June 3, 2016

Bayside Bowl

Permit Review Comments Responses

A5-8

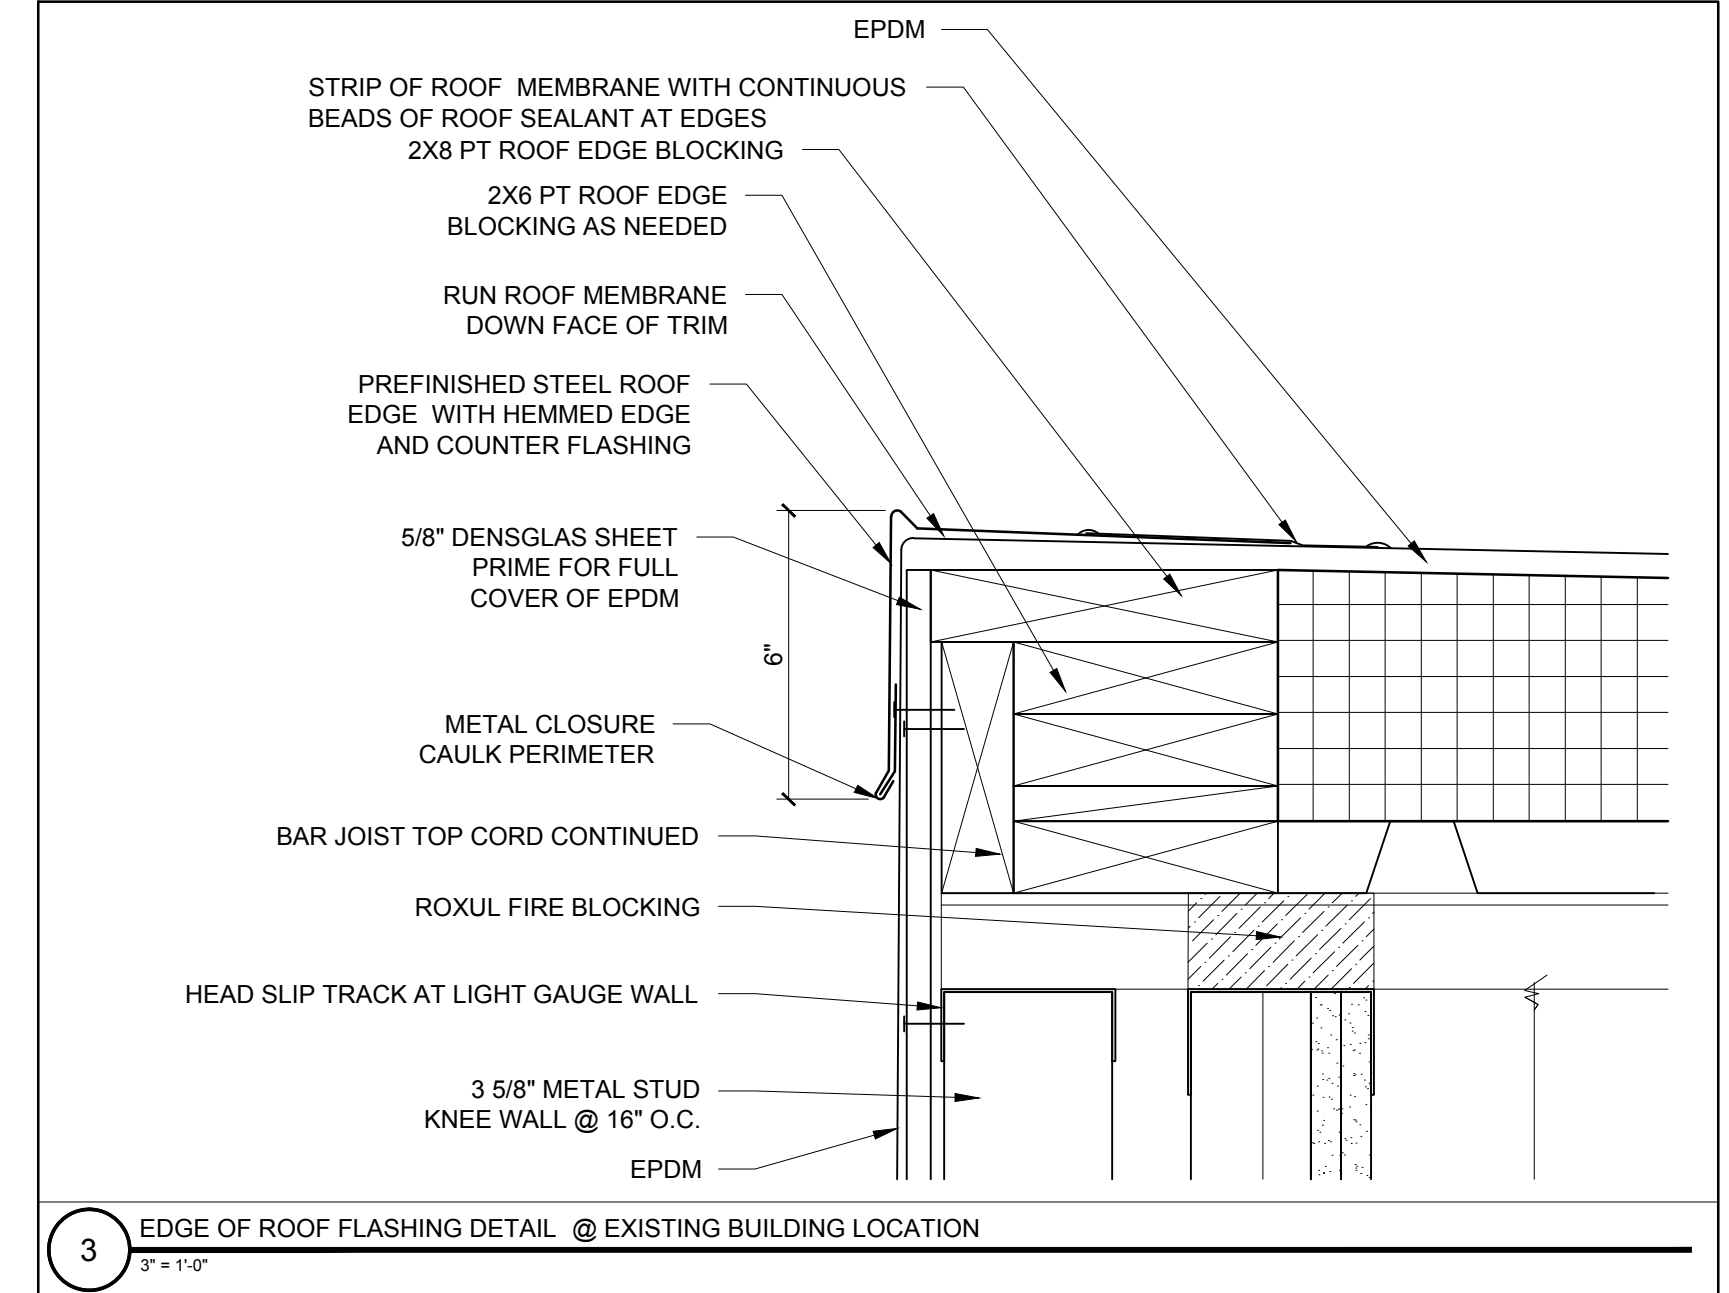
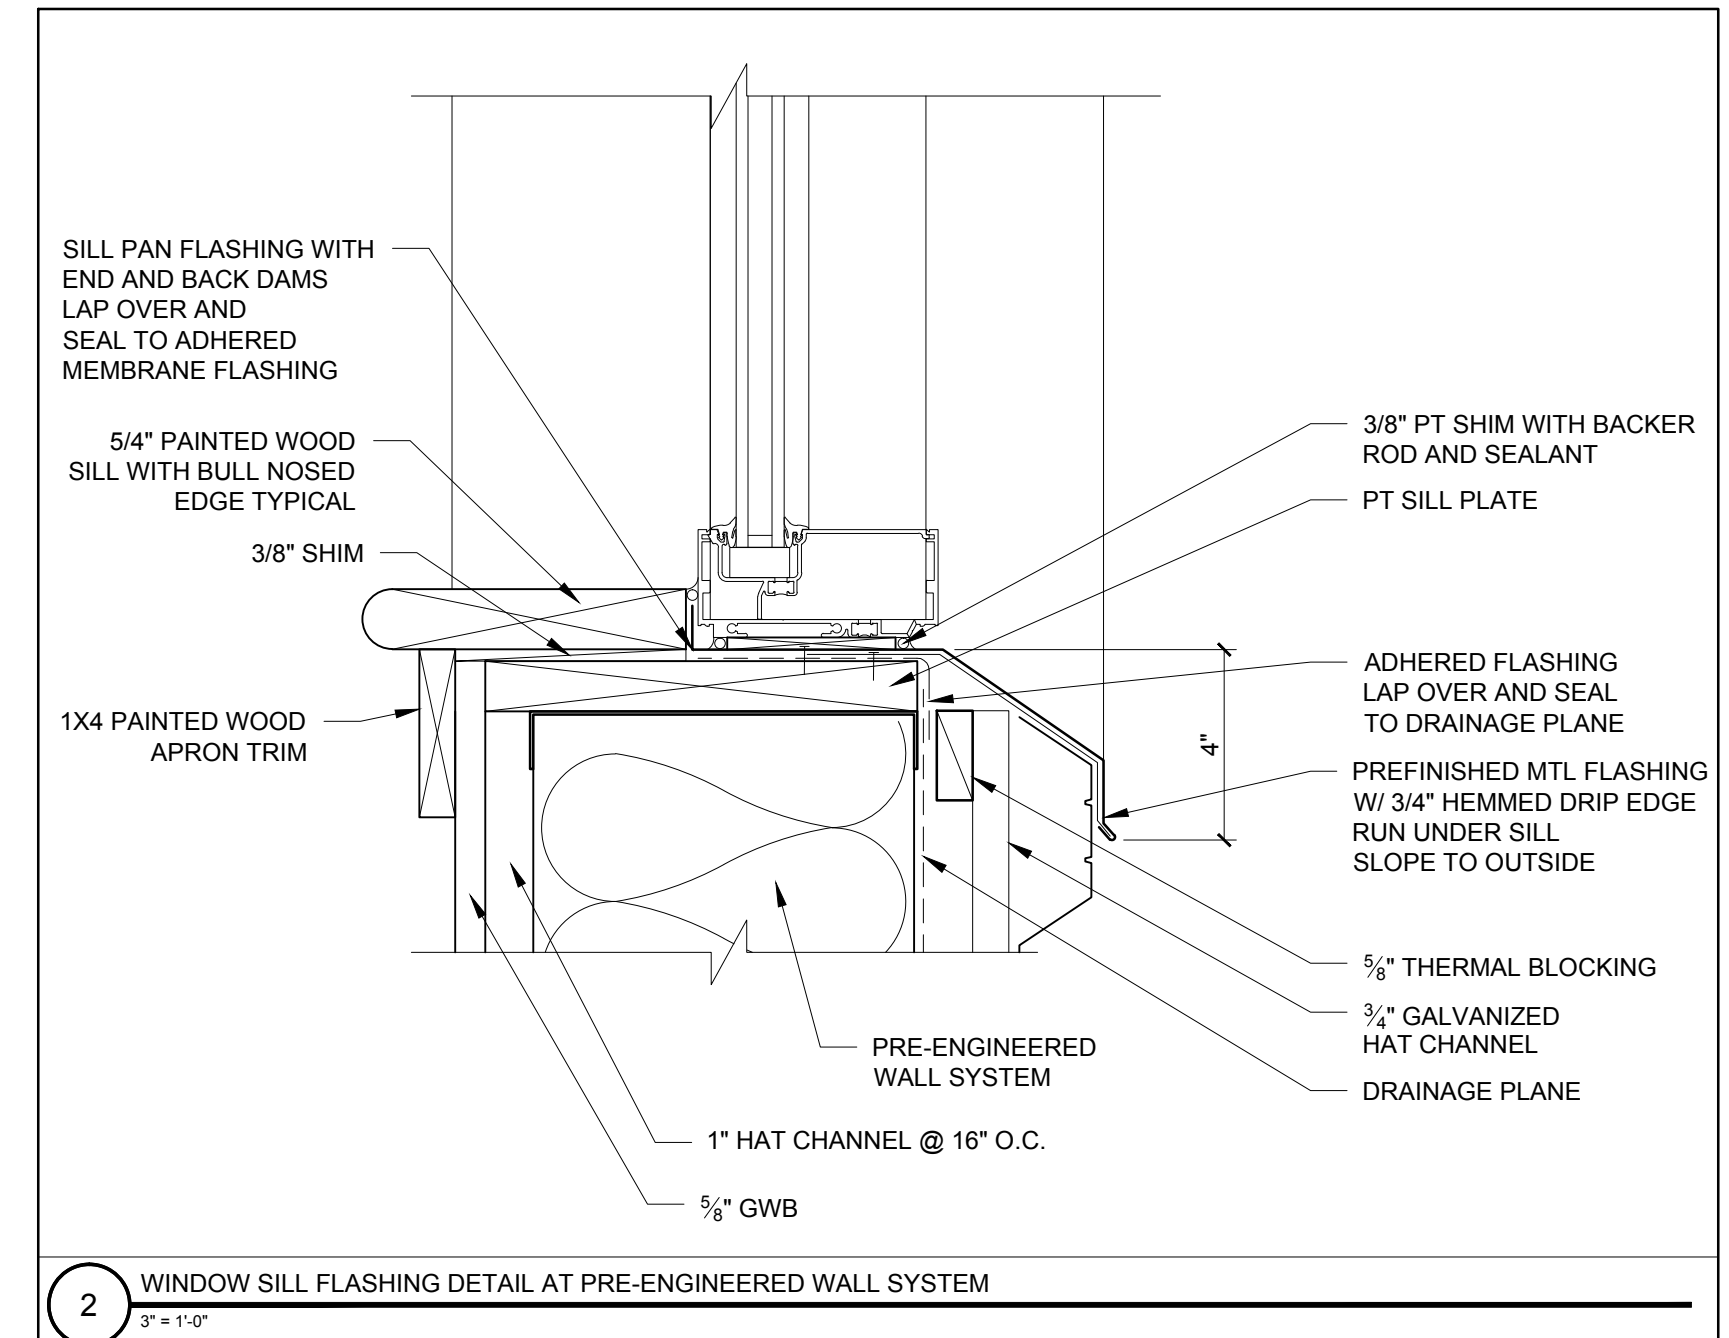
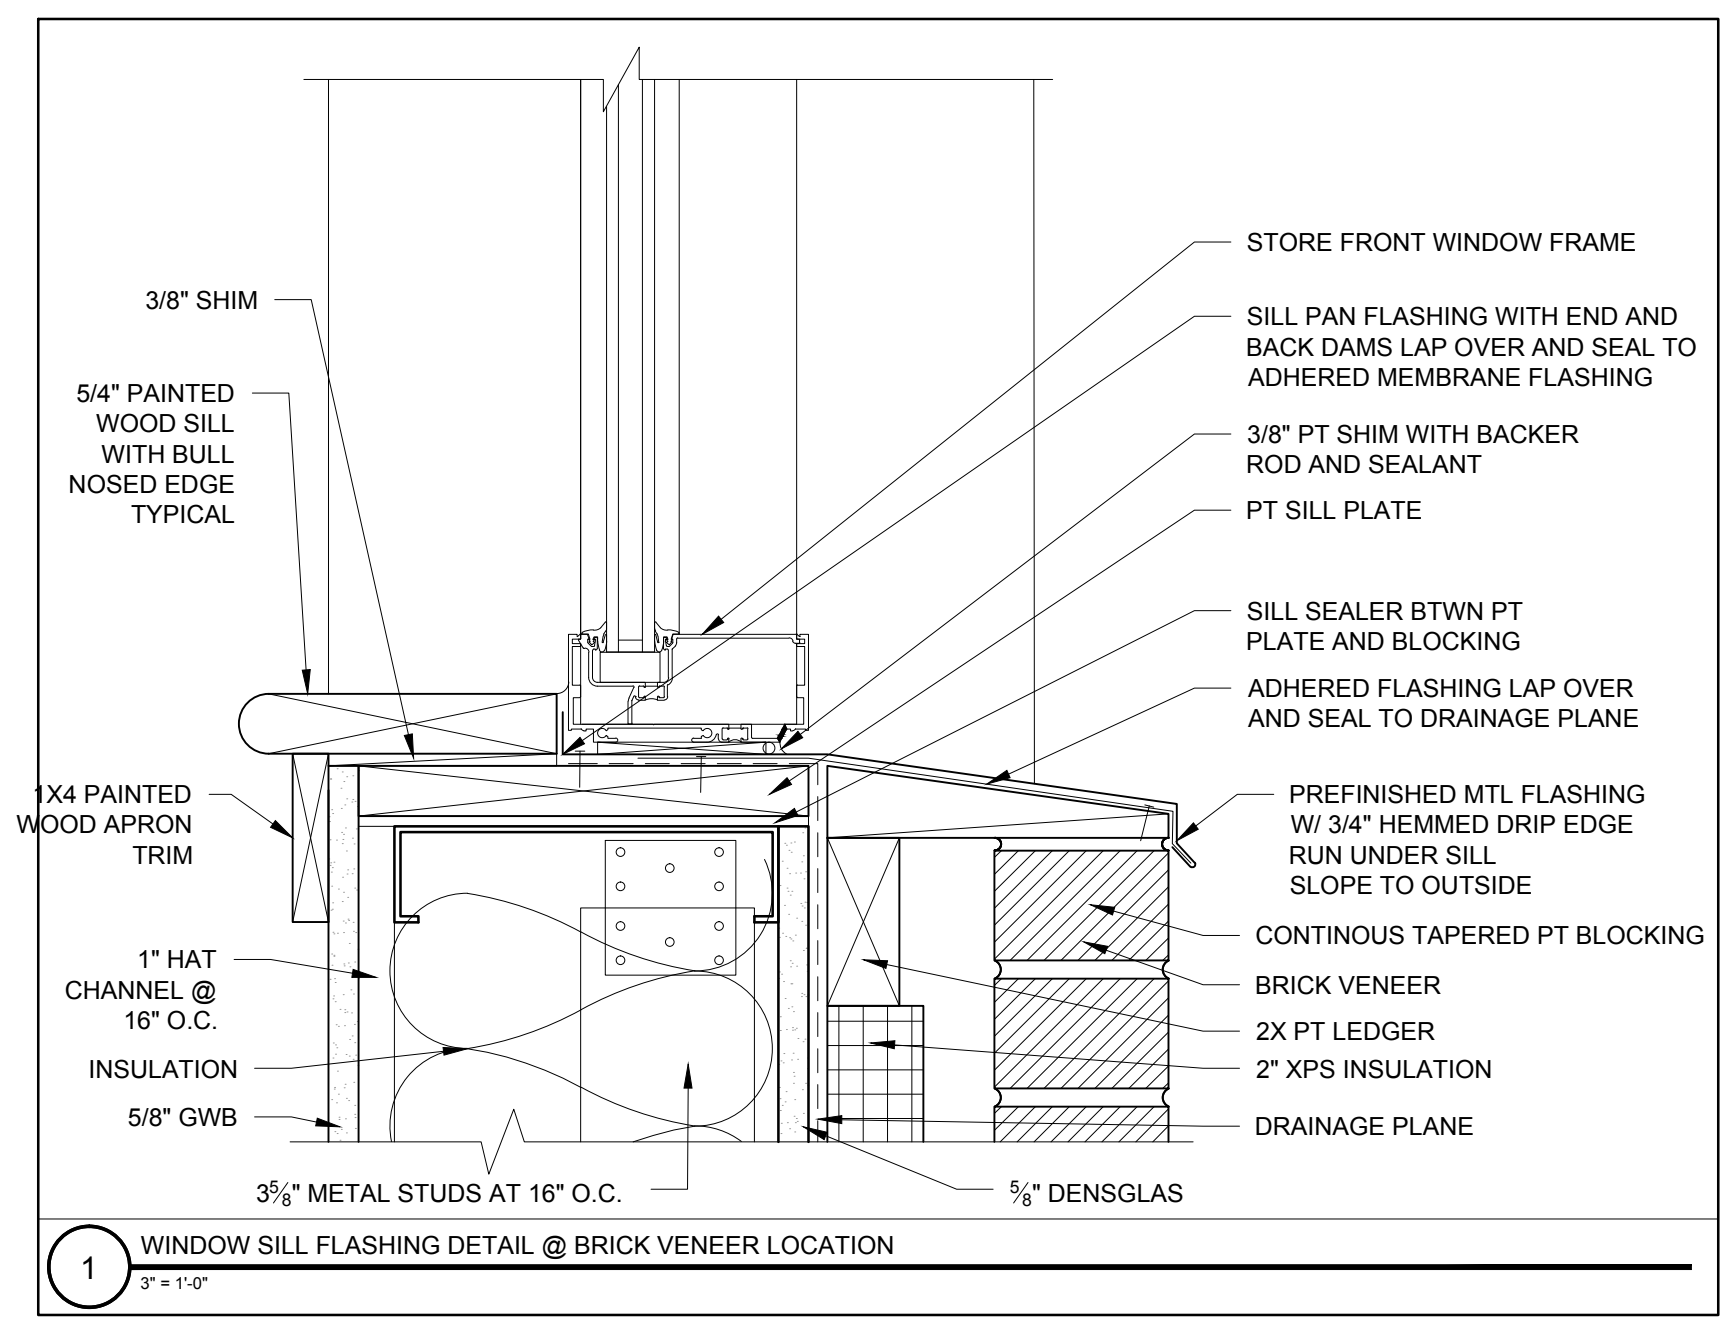
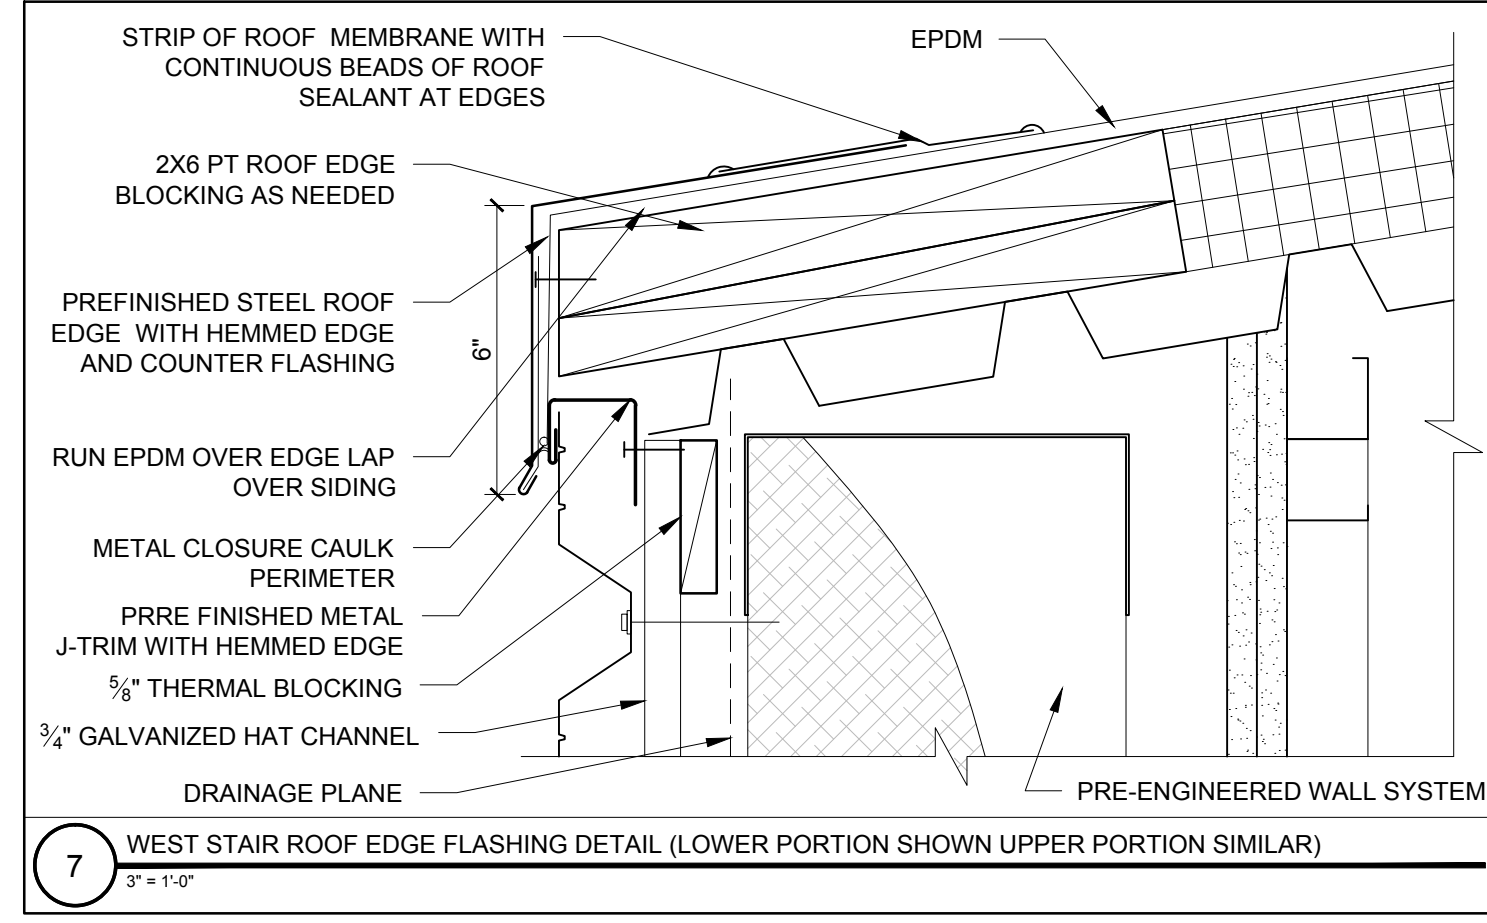
- 5.) A5-8, please see the revised sheets A5-1, A5-5, A5-6, A5-7 and A5-8 showing Fire treated roof blocking in lieu of PT blocking.
- 6.) A5-4, the detail was incorrectly tagged it is corrected as Detail 4/A5-2 on the attached sheet.
